**WEST SUSSEX COUNTY COUNCIL
STRATEGIC PLANNING CONSULTATION**

SUBJECT: A/44/17/OUT - Outline application (with all matters reserved) for demolition of existing buildings on site and the erection of a mixed use development comprising 90No. residential units and a care home (Use Class C2 and C3) & ancillary facilities, including railway crossing, together with associated access, car parking & landscaping.

Land west of, Brook Lane and South of A259, Angmering, BN16 3JL

MASTER PLAN

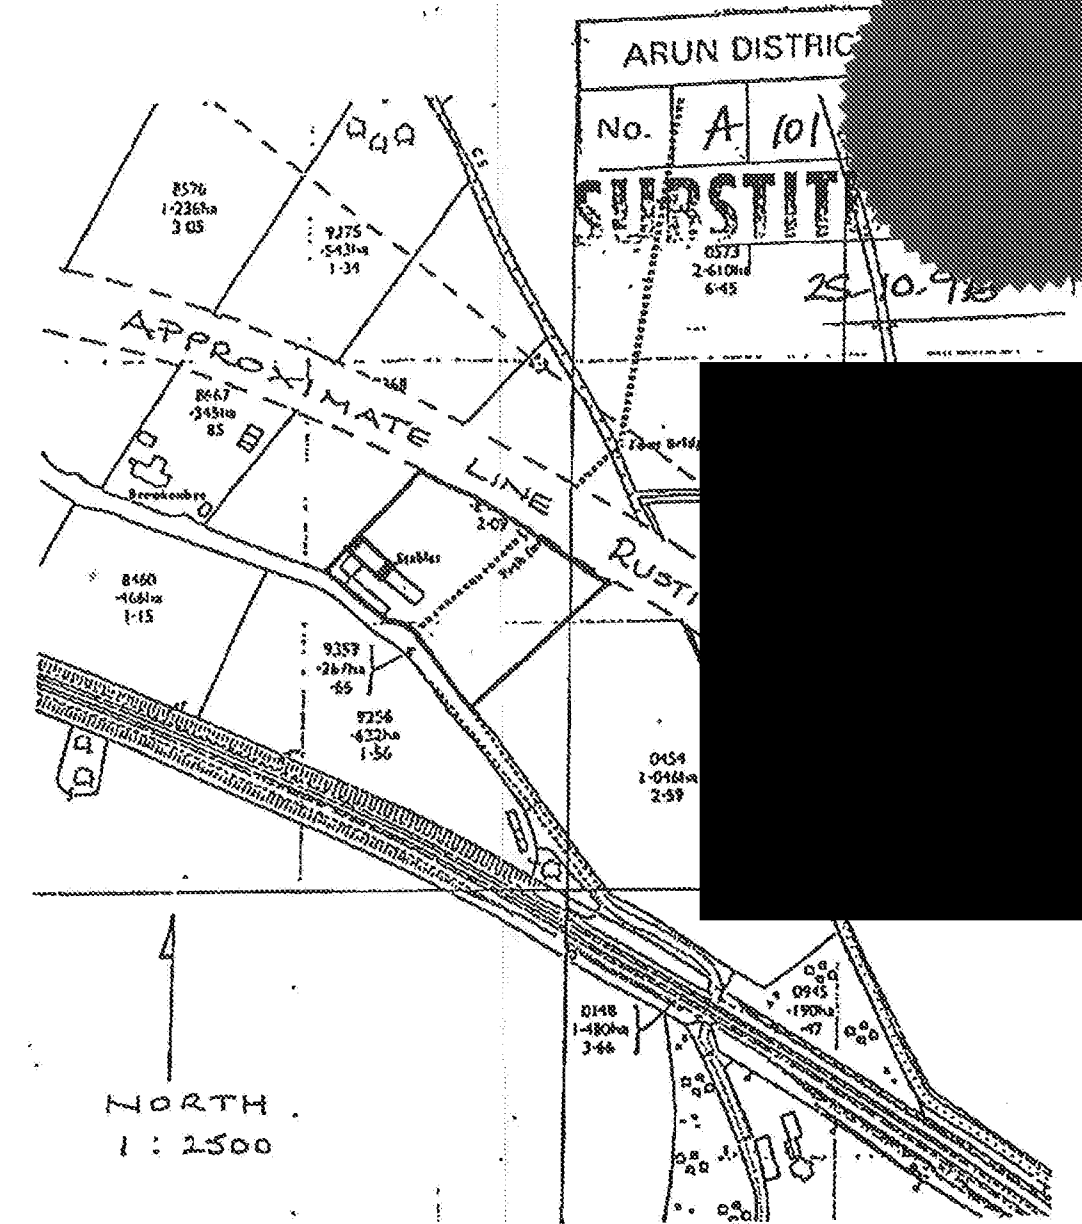
The Indicative site masterplan highlights 4 turning heads within the development that would appear to provide satisfactory access.
